From: Simon Davis
Sent: 21 December 2017 15:27
To: Planning.Responses
Subject: FW: 36 Corbishley Road BR/289/17/DOC

Further Drainage Comments

From: Paul Cann
Sent: 21 December 2017 15:26
To: Simon Davis
Subject: RE: 36 Corbishley Road BR/289/17/DOC

Client
Mrs Patricia Paul
Drawing Title
Surface Water Drainage

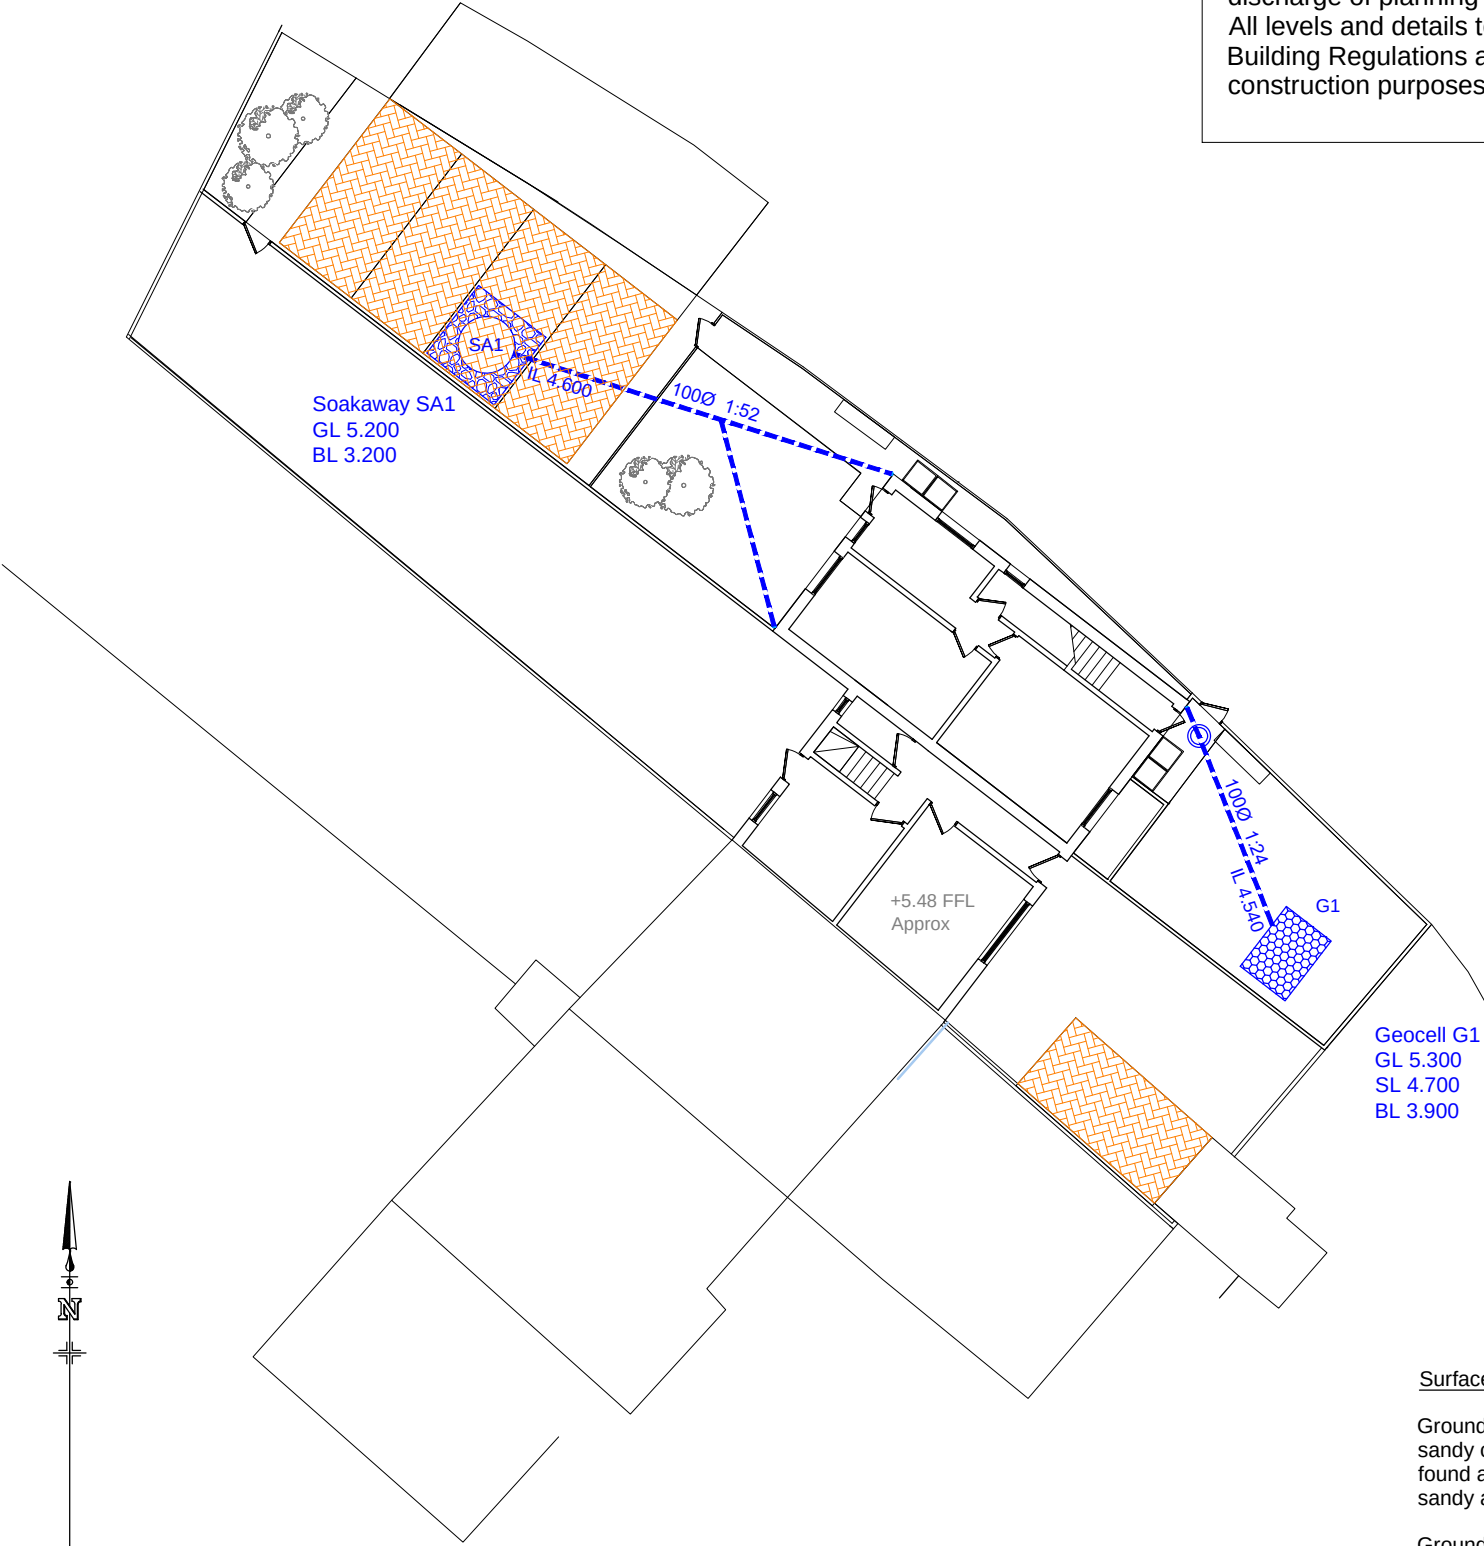
1. Provide silt trap manhole upstream of PCC ring soakaway.
2. Provide construction detail to show how permeable pavement construction interacts with PCC ring soakaway.
3. Provide construction detail/calculations for the standalone section of permeable pavement.
